From: Colin Giddings
Sent: 01 August 2018 16:24
To: Anita Gardner
Cc: Planning
Subject: FW: LU/191/18/DOC

From: Colin Giddings
Sent: 25 July 2018 14:03
To: Anita Gardner
Subject: LU/191/18/DOC

I've had a quick look at the conditions discharge documents which relate to EH/Site Licensing and would comment as follows:

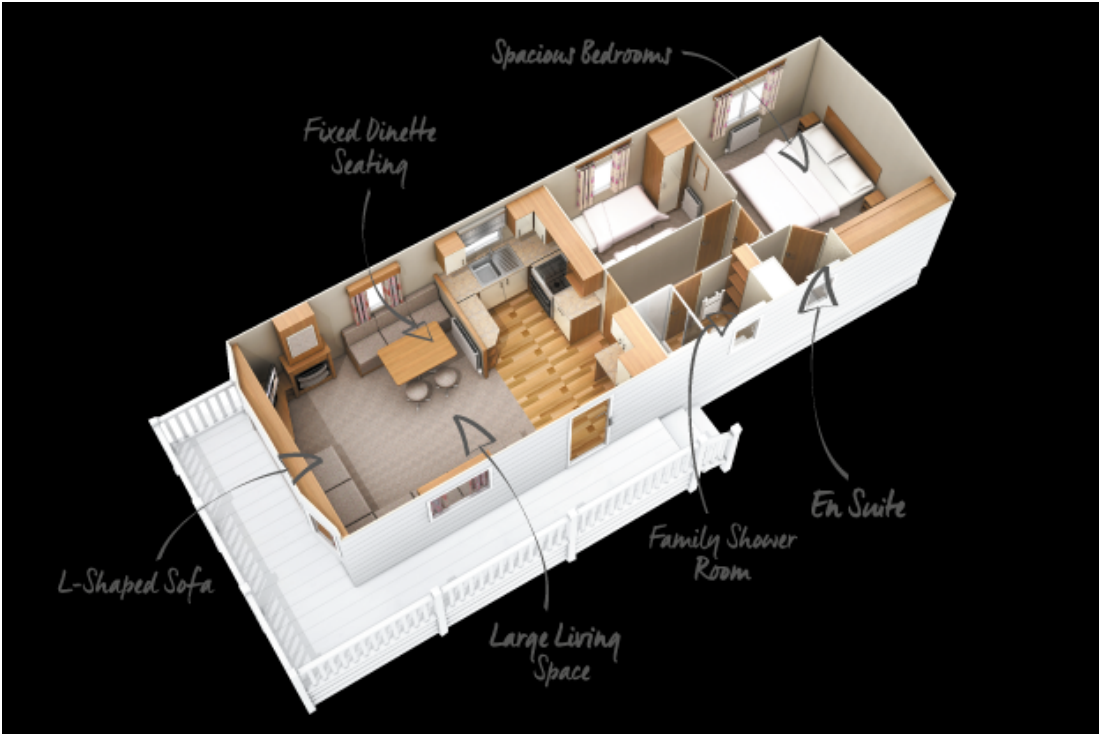
This is not an Environmental Health proposal, however, the construction and positioning of the shed will be critical in regard to the safe use of the site, particularly where a timber model is proposed. There are insufficient details at present.

There is mention of a plan for the proposed wooden structure but I have not had sight of this. The site will need to comply with spacing and safety standards when in operation. Without details of the proposed structure I cannot comment further.
